ADDENDUM 01

To: Bidding General Contractors and Subcontractors
From: Ben Walter, CWS Architects
Regarding: **191 Marginal Way Retail Center** – Portland, Maine
Subject: **Site Addendum 01**

Title
SITE LAYOUT PLAN

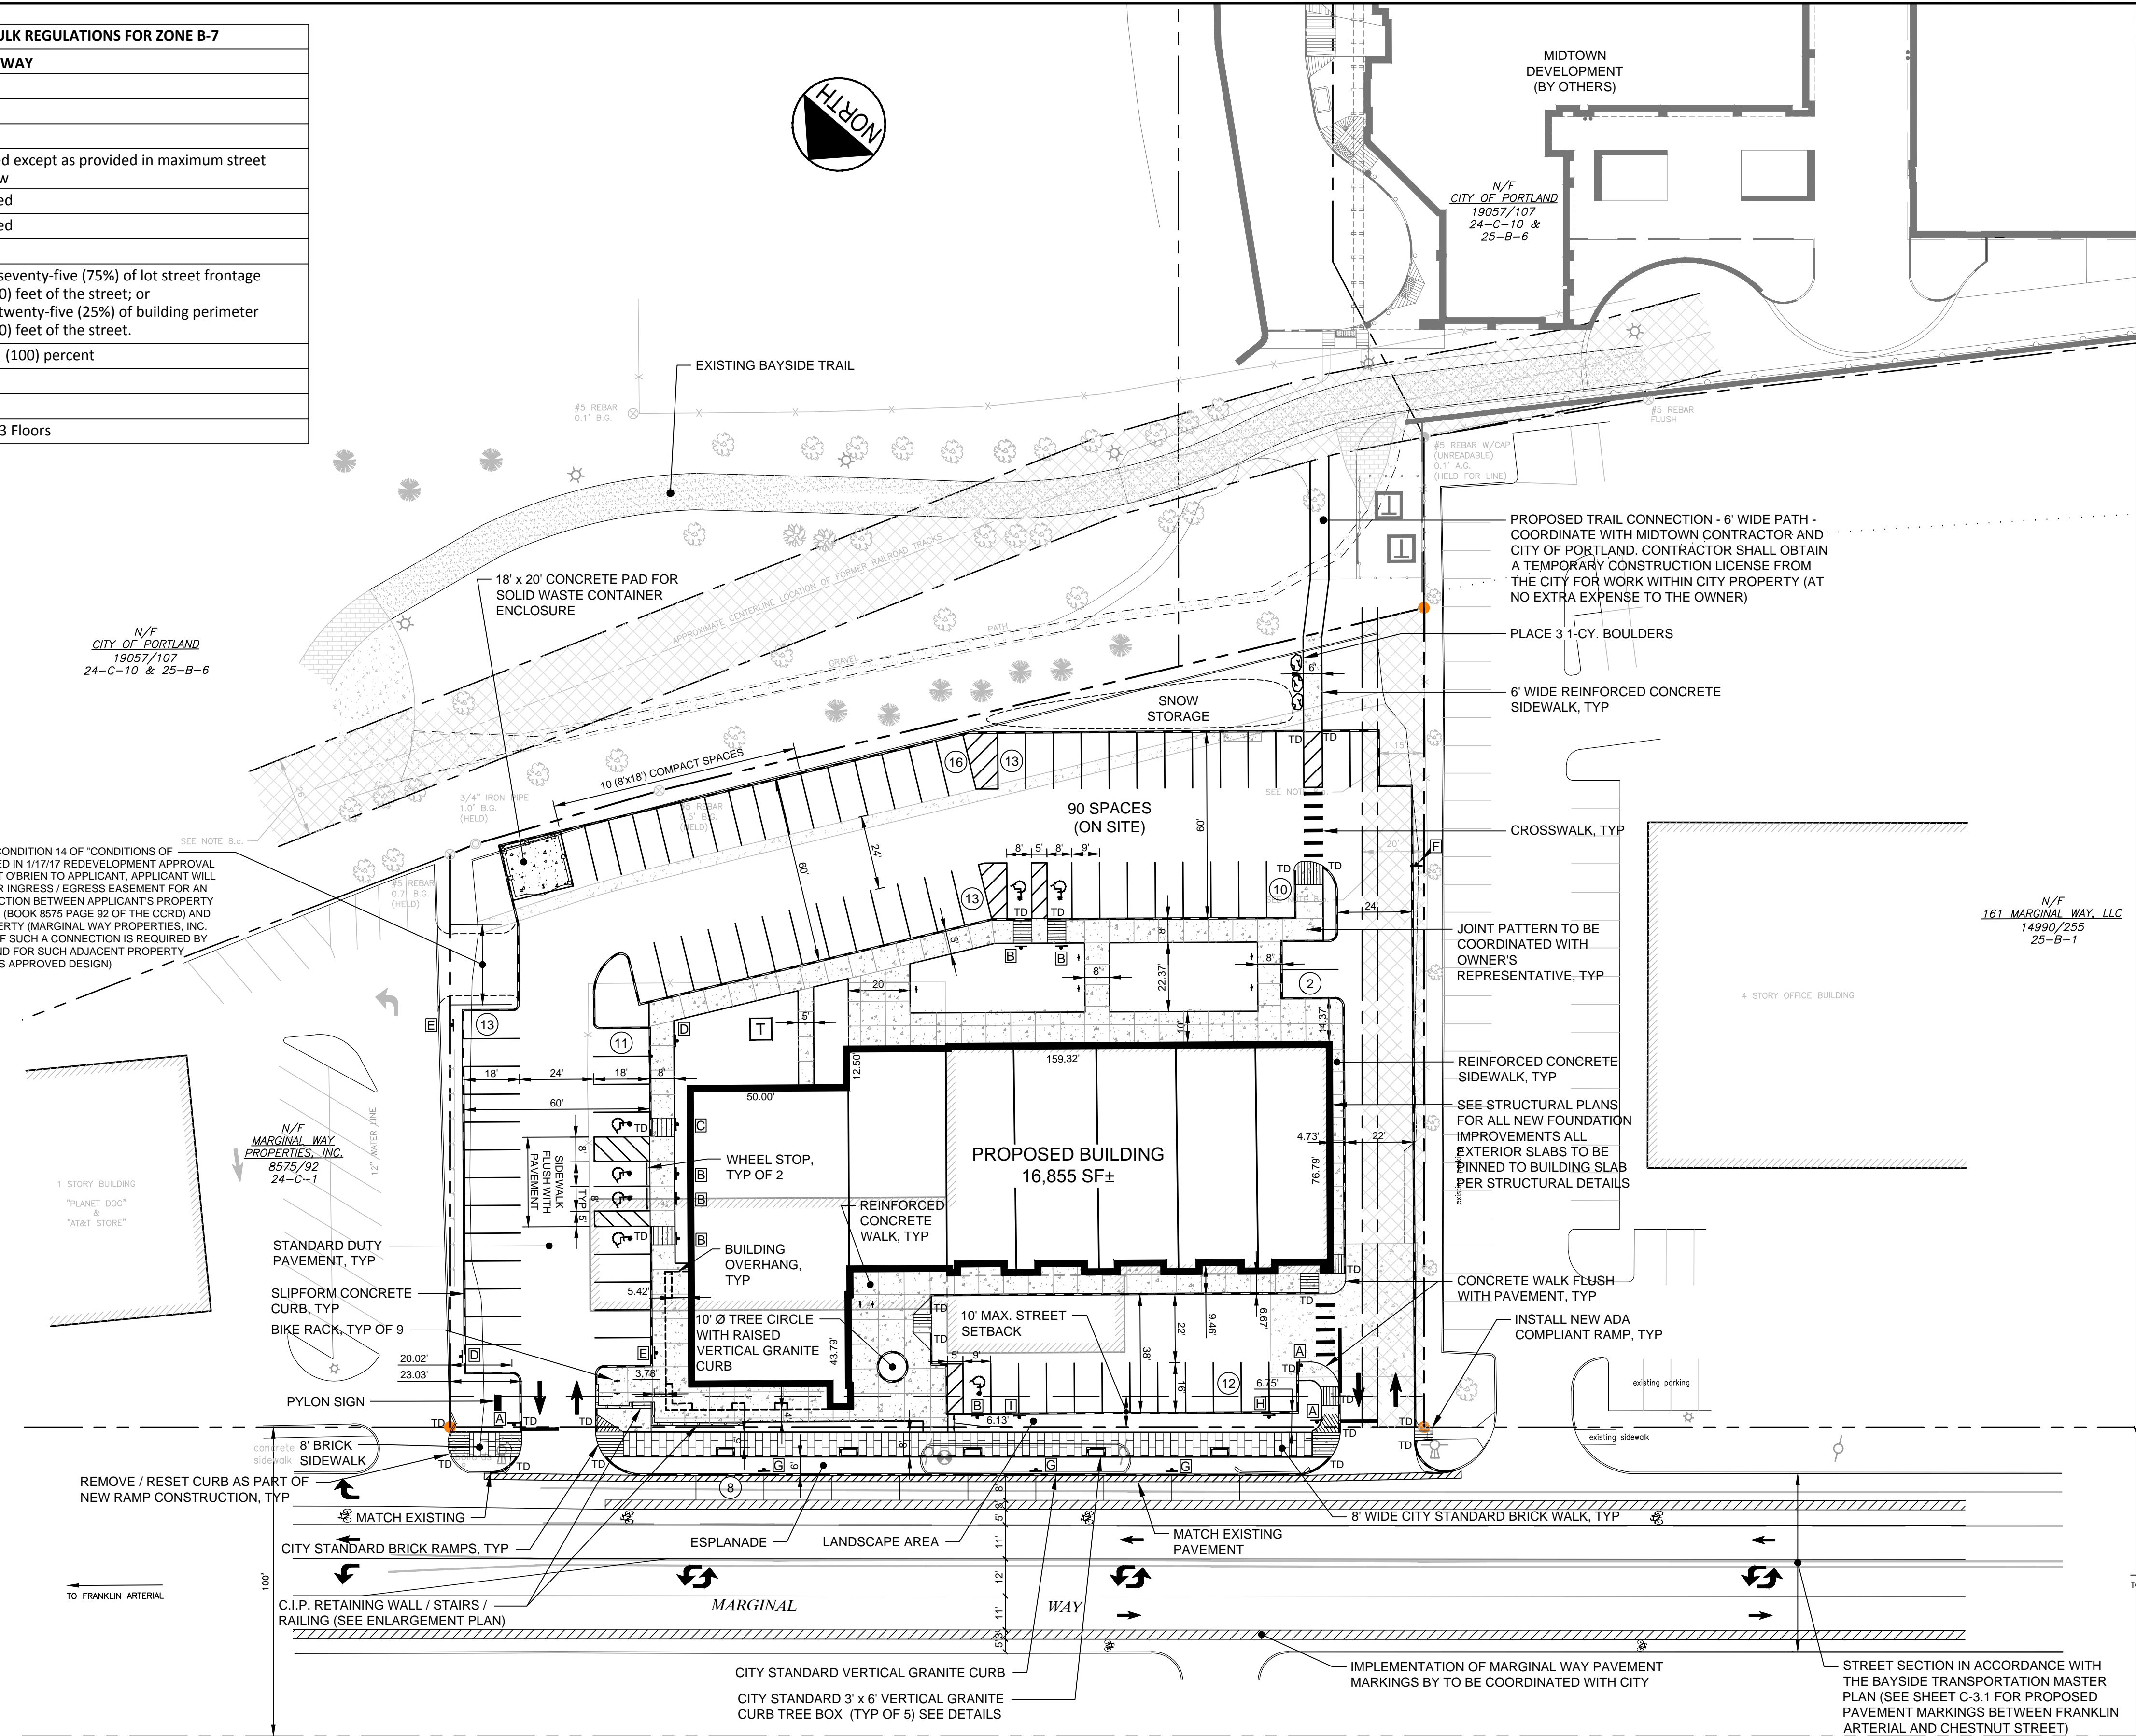
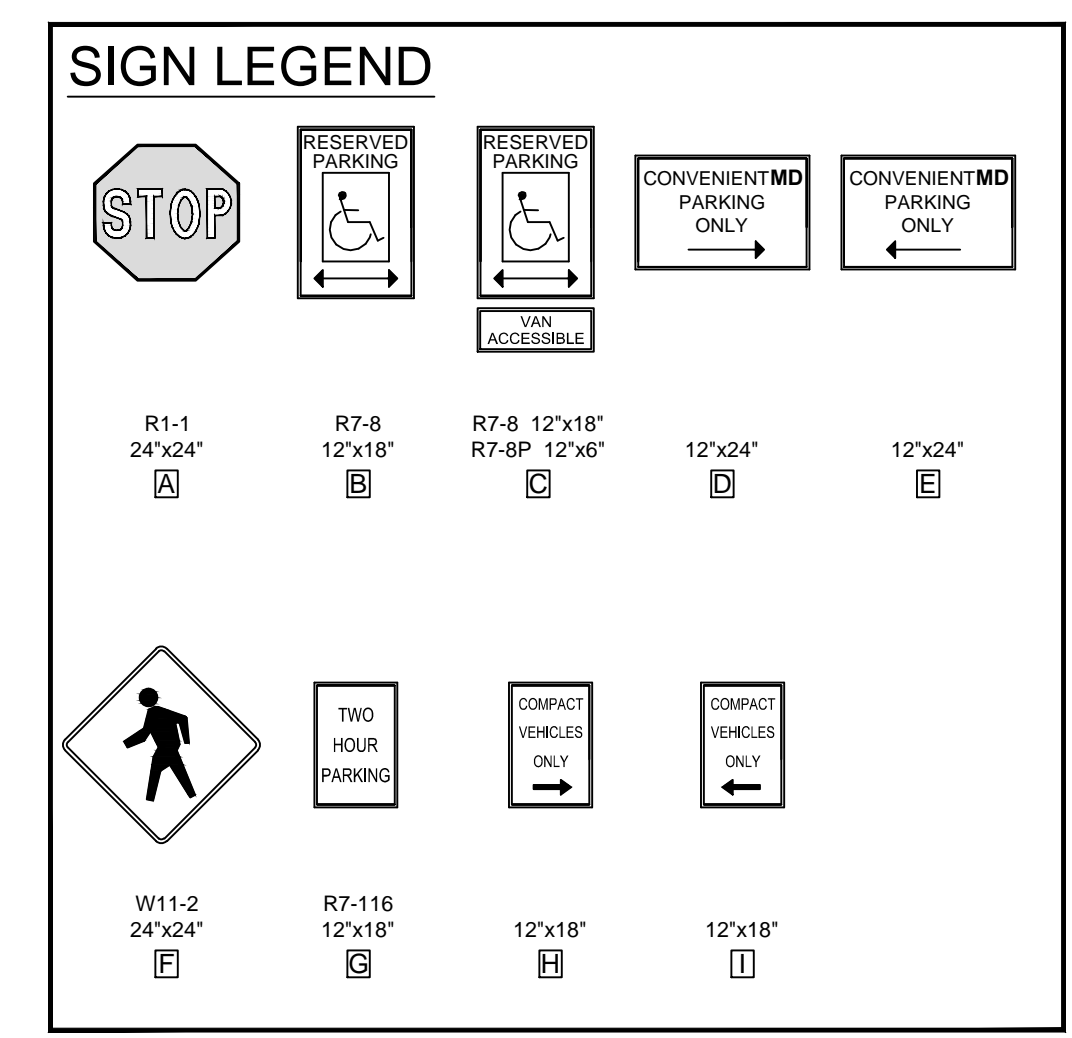
1. Revise sheet C-3.0 SITE PLAN LAYOUT per the attached CSK-2, to include clarifications to the van-accessible parking space as shown.
2. Revise sheet C-4.0 GRADING AND DRAINAGE PLAN per the attached CSK-1, to include a footing drain around the entire perimeter of the building.
